CARRIAGE MEADOWS SOUTH AT LORSON RANCH FILING 2

**CARRIAGE MEADOWS SOUTH
 AT LORSON RANCH
 FILING NO. 2**
 El Paso County, Colorado
 PUD & PRELIMINARY PLAN

PCD FILE NO.: PUDSP-18-5

### TYPICAL STREET CROSS-SECTIONS

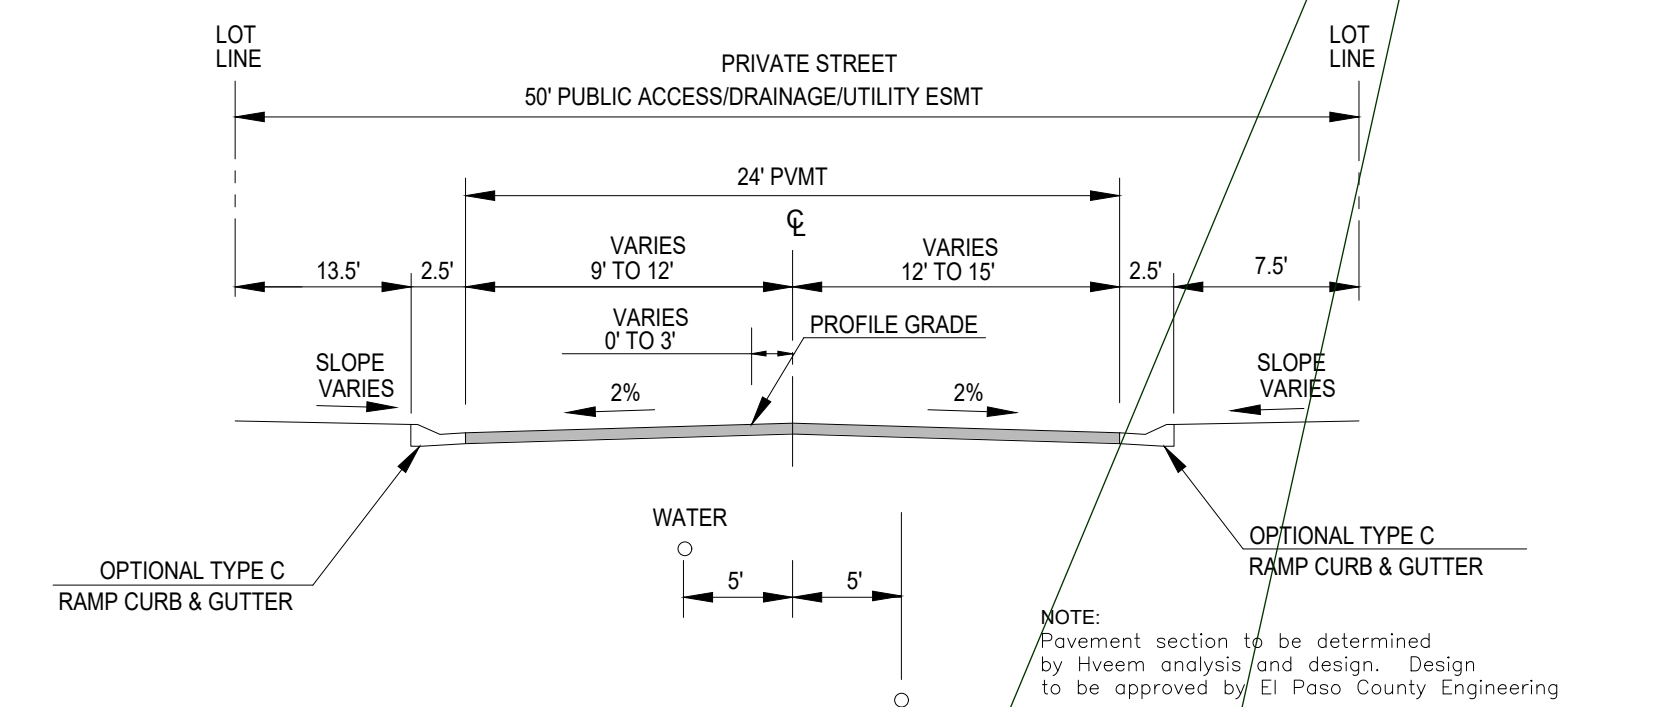
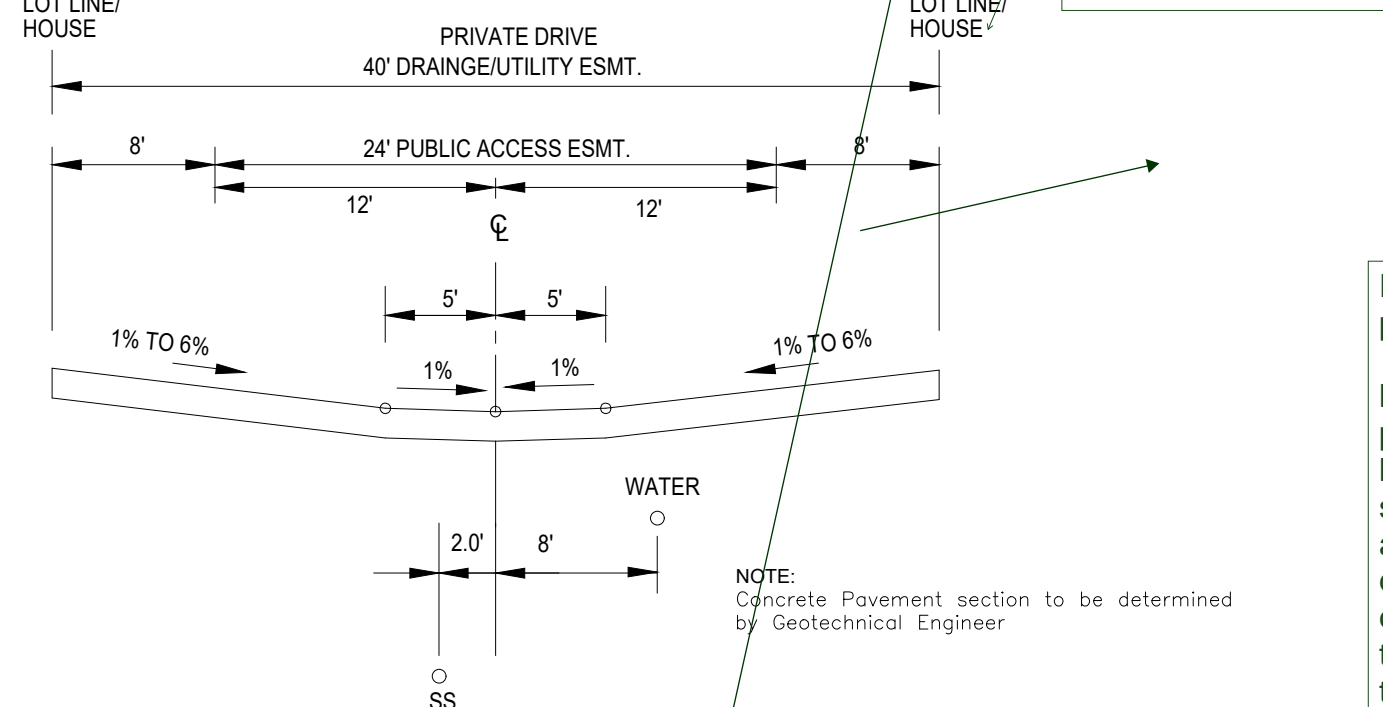
No Parking Signs-

Parking may cause a public safety concern. Provide a specific letter that the Fire protections district has no issues with on site street parking and length of driveway as overhang will block the roadway.

NO parking Signs

### TRACT MAP & TABLE

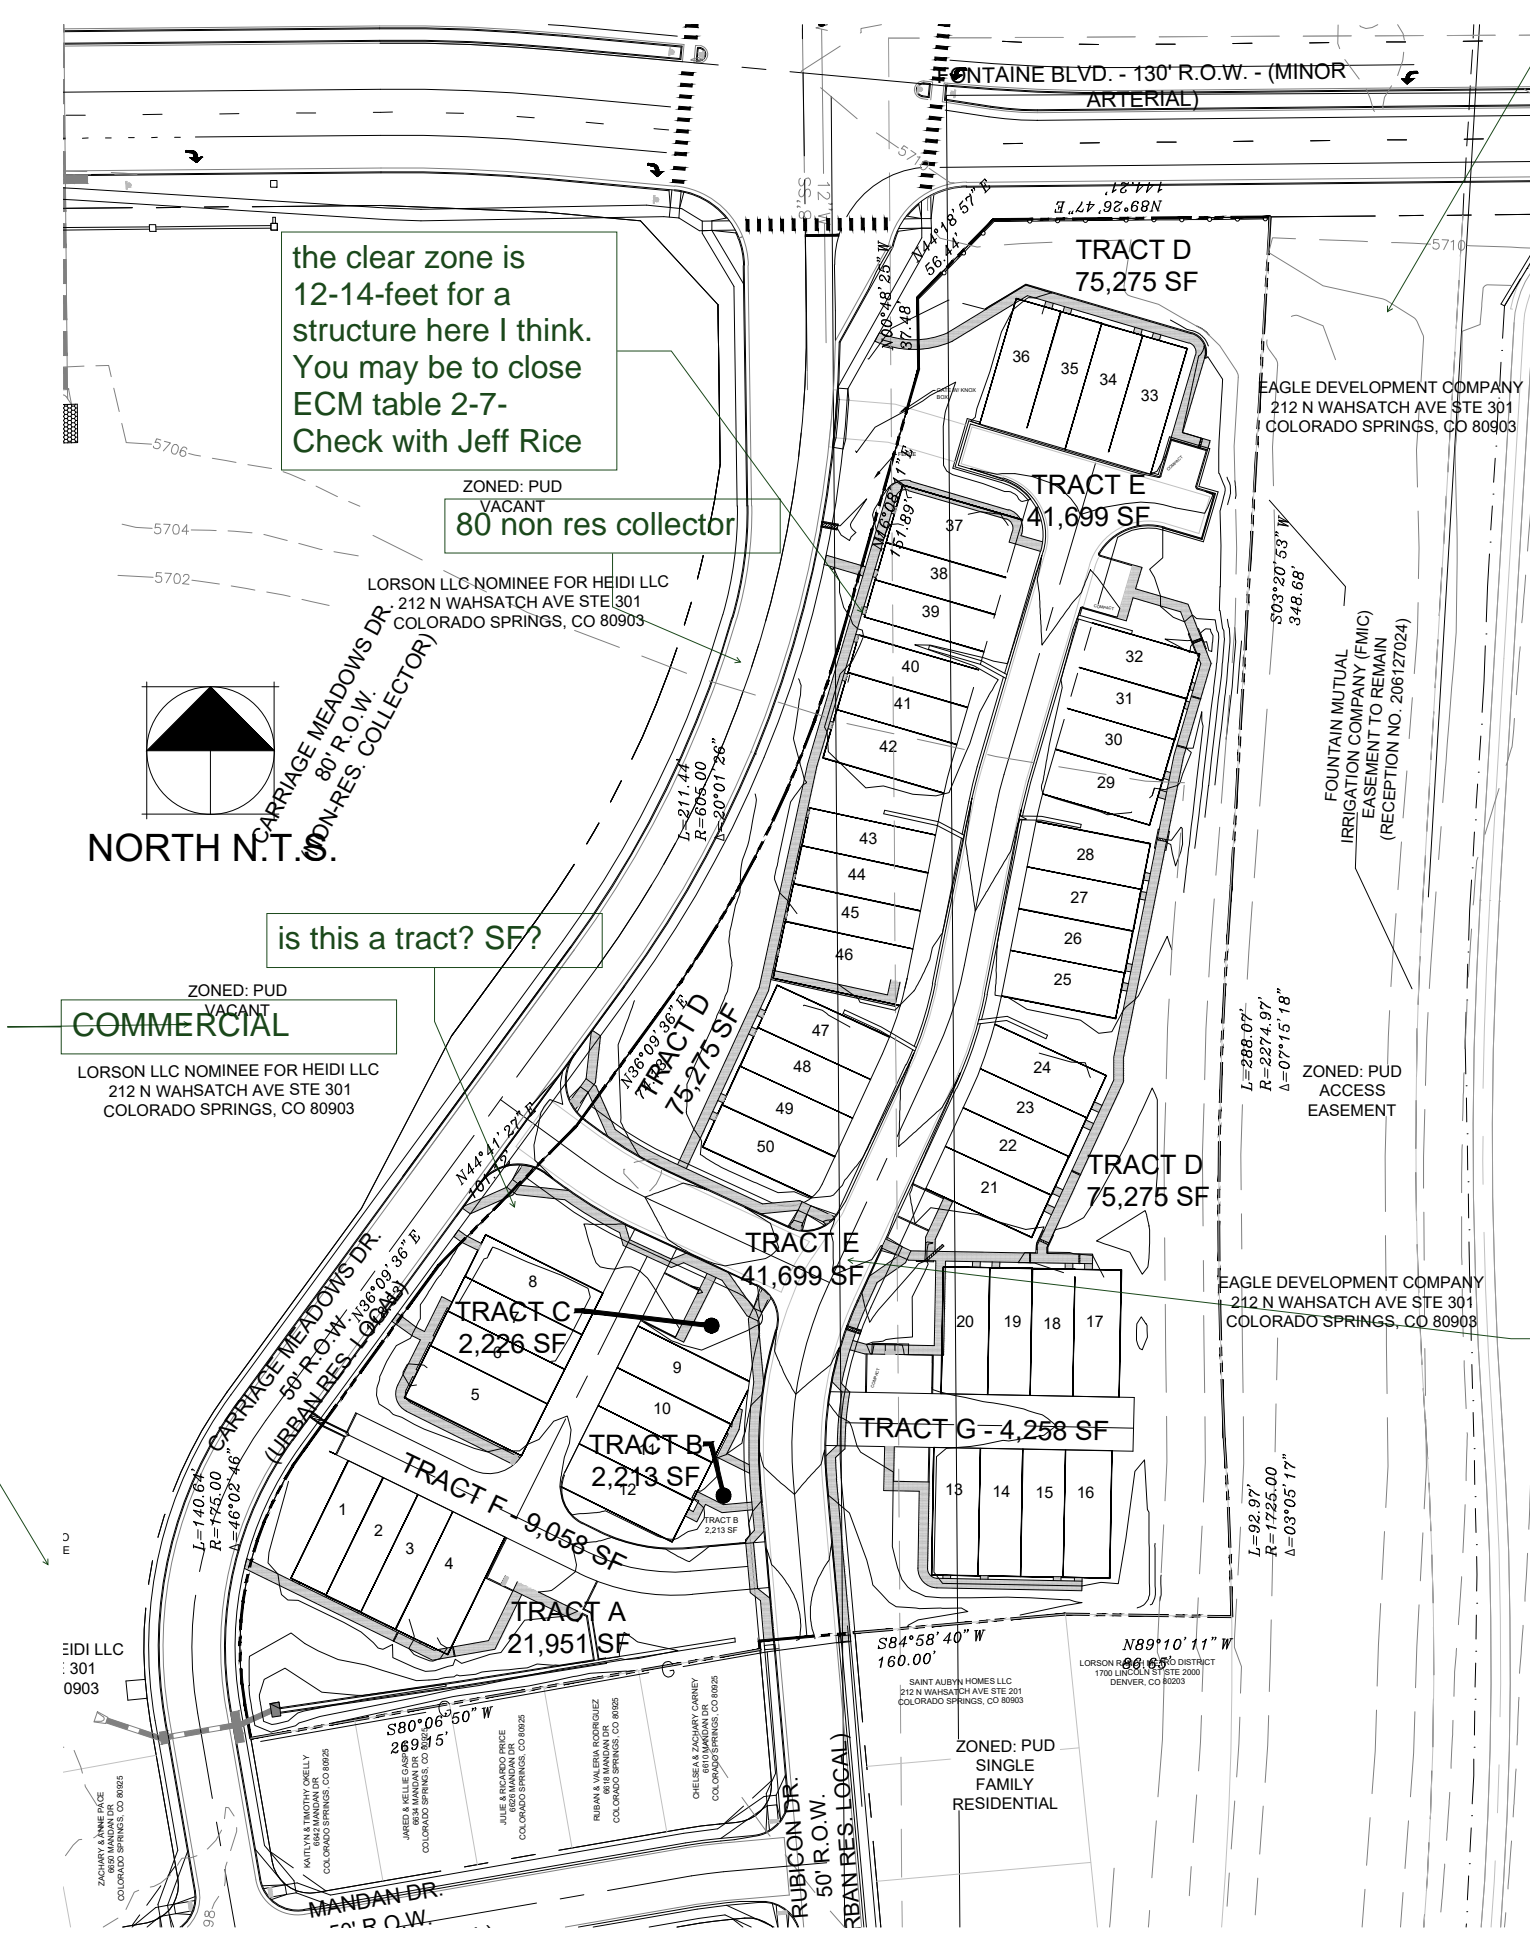
Provide a parking table: Justify the parking; identify how many bedrooms, and how many spaces included in garage and in a 10 foot driveway plus guest parking areas.

### TYPICAL LOT DIAGRAMS

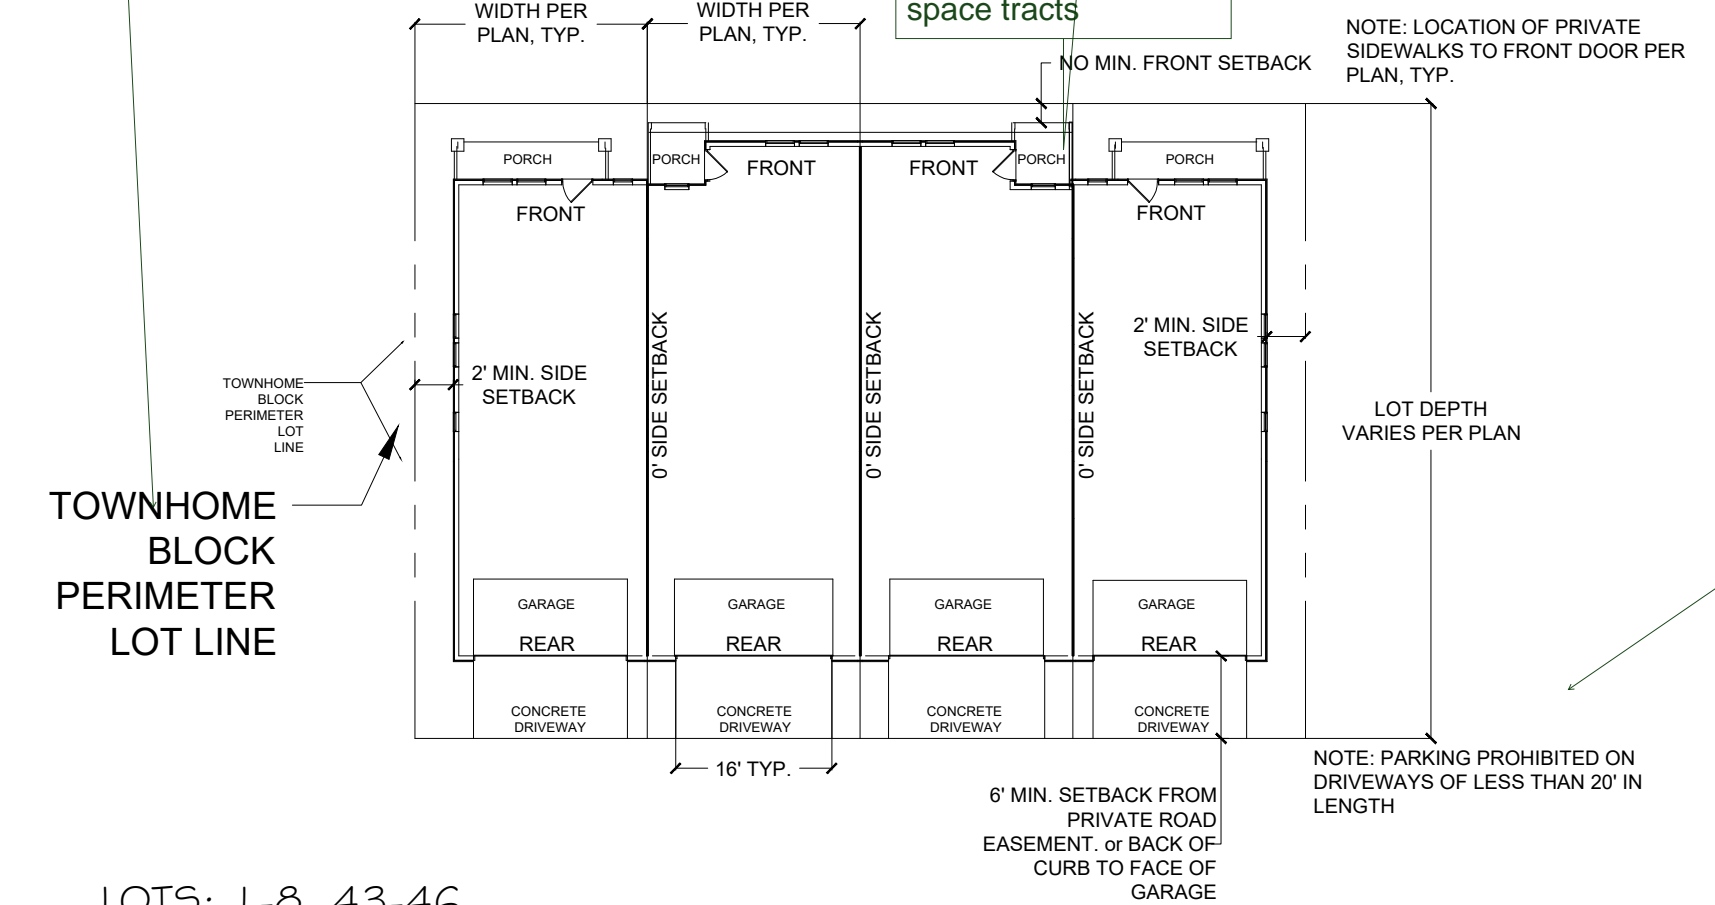
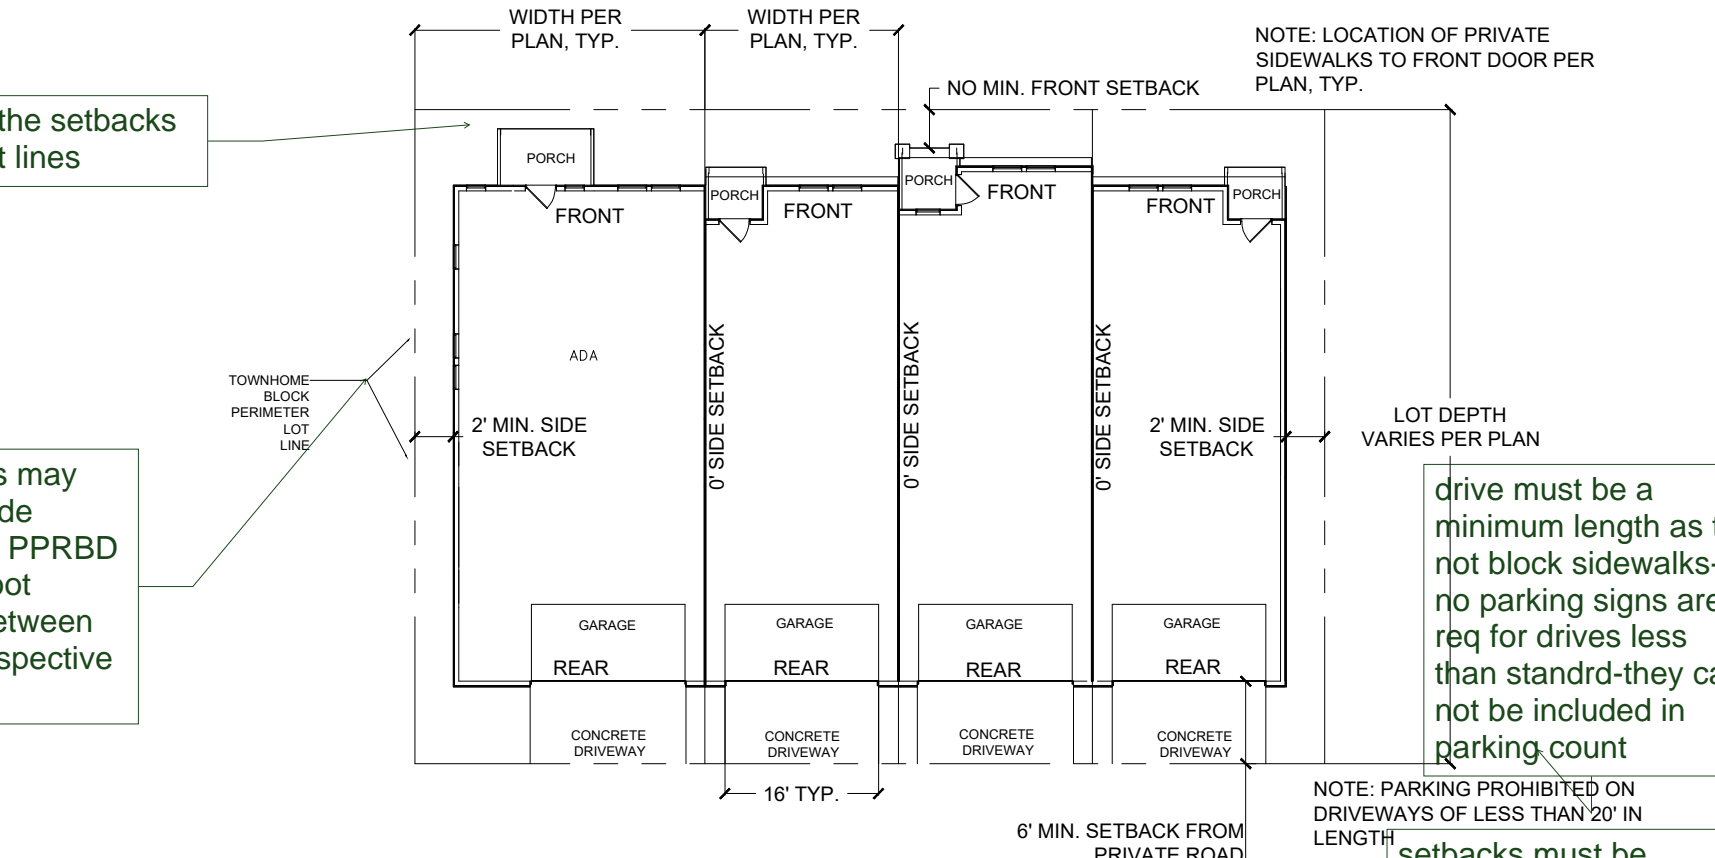
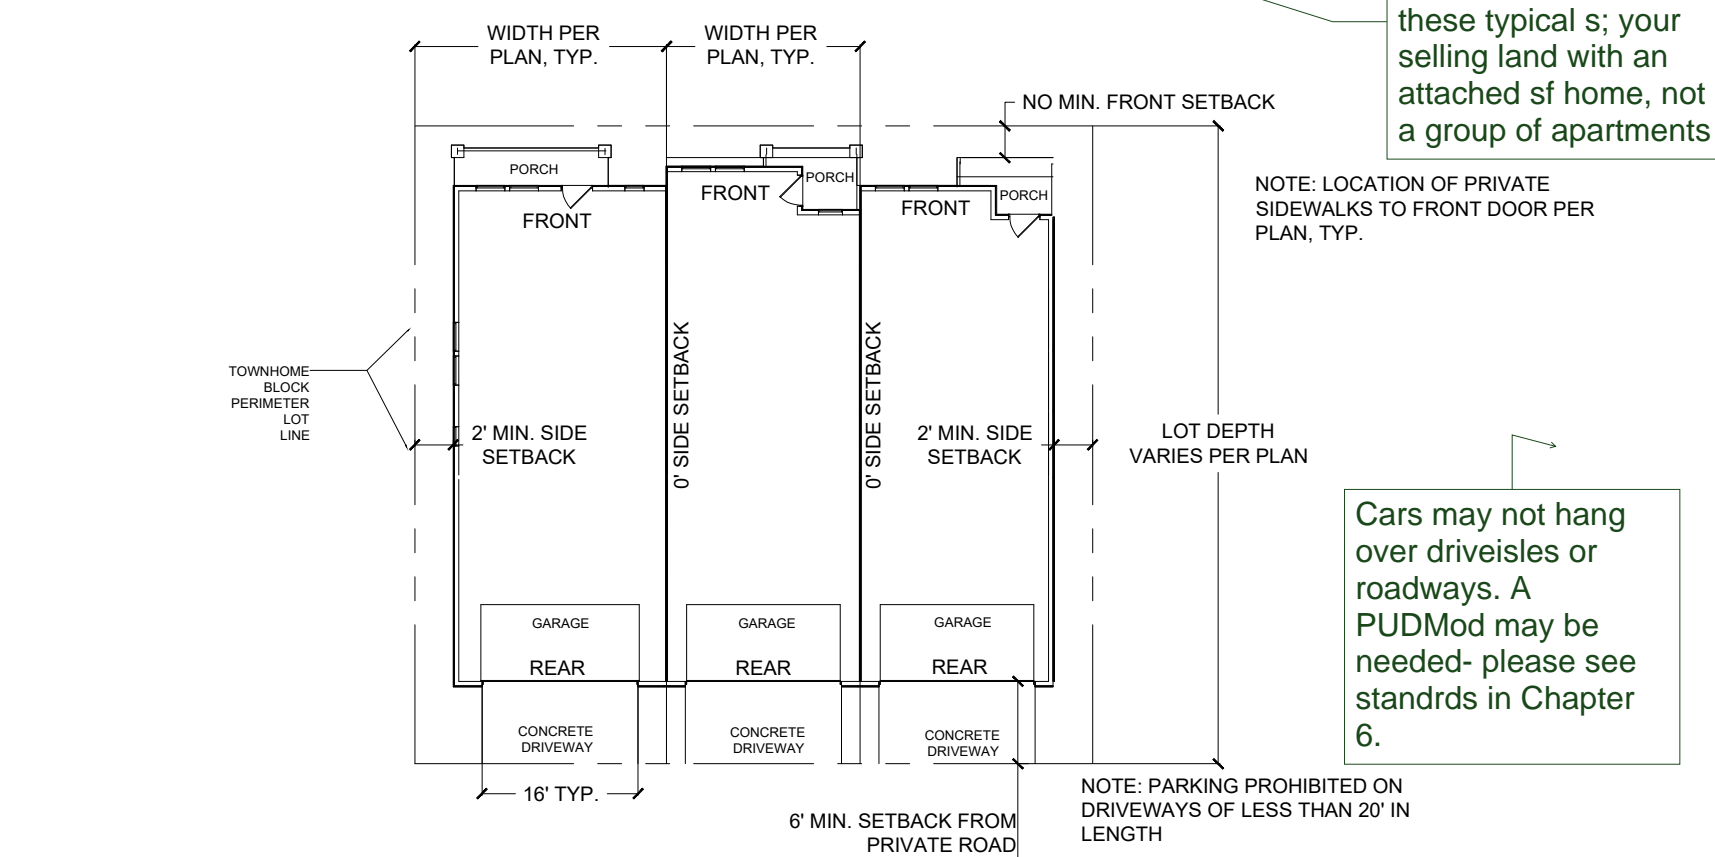
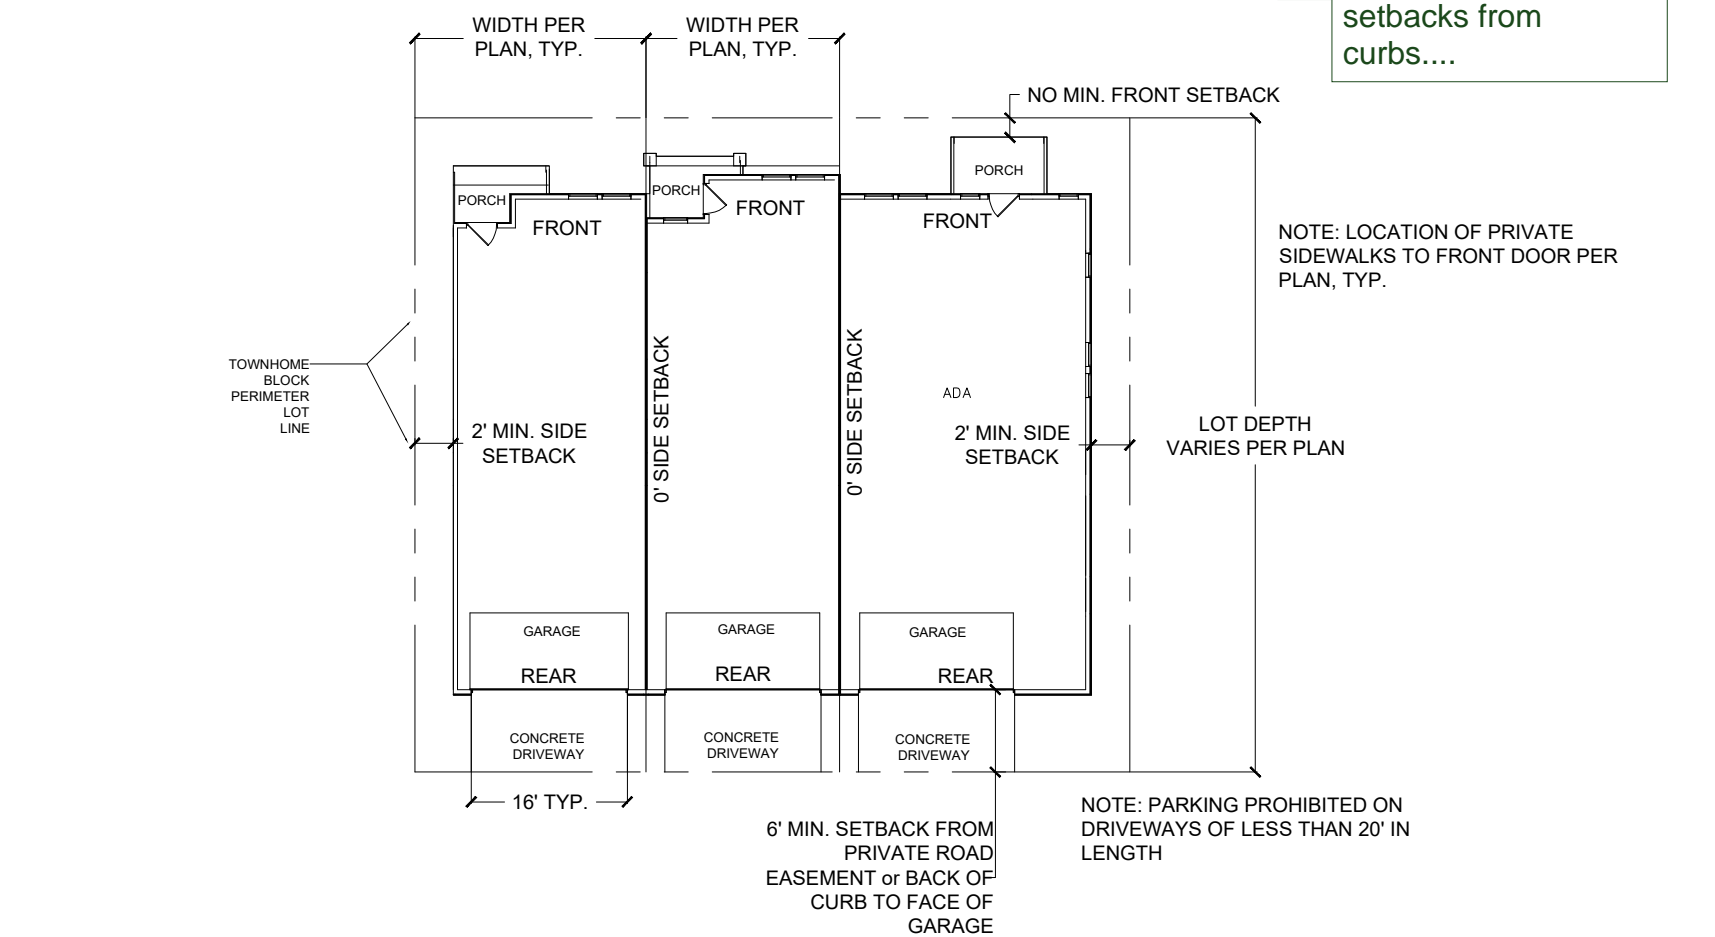
Are these lot lines? Depict the lot lines with one line type and label.

The end units may need 5 foot side backs. Does PPRBD require 1- foot separation between buildings irrespective of lot lines?

how will the utilities fir in with no setbacks? Where are the easements for utilities per lot?

Cars may not hang over driveisles or roadways. A PUDMod may be needed- please see standrds in Chapter 6.

public ROW and Private road or drive?
